2 March 2015

CR2015/000436

SSD 6284 – PROPOSED WATER TREATMENT PLANT UPGRADE, LOT 2 DP540063, HAMMOND AVENUE (STURT HIGHWAY), WAGGA WAGGA.

Photo 19: Sight distances to the west from the WTP entrance (nghenvironmental).

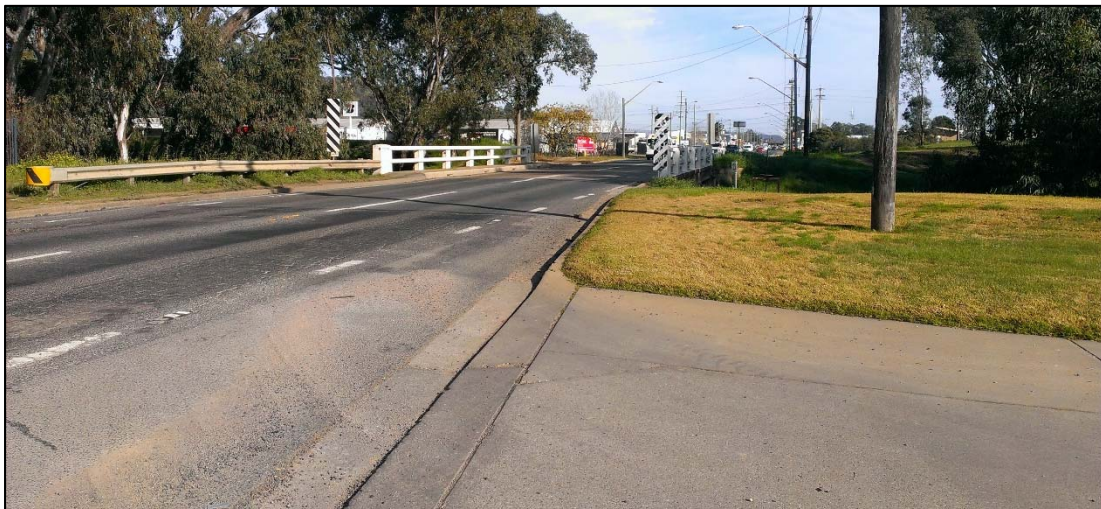
The submitted documentation does not propose any significant changes to the existing vehicular access points to the site from the Sturt Highway or to the traffic flow through the subject site, however for road safety reasons consideration should be given to delineating the 2 way traffic flow at the entrance driveway to the highway. The provision of a splitter island or the like within the driveway to separate entering and exiting traffic movement paths would decrease the potential for vehicles exiting the site to cause delay to vehicles entering the site from the highway

2. The driveway to the Sturt Highway (Hammond Avenue) shall have the ingress and egress travel lane separated by a raised splitter island. The splitter island shall not protrude onto the carriageway. As a minimum the splitter island is to be a raised concrete structure within the site and painted on the driveway within the road reserve. Associated directional marking and signage is to be installed in accordance with Australian Standards.
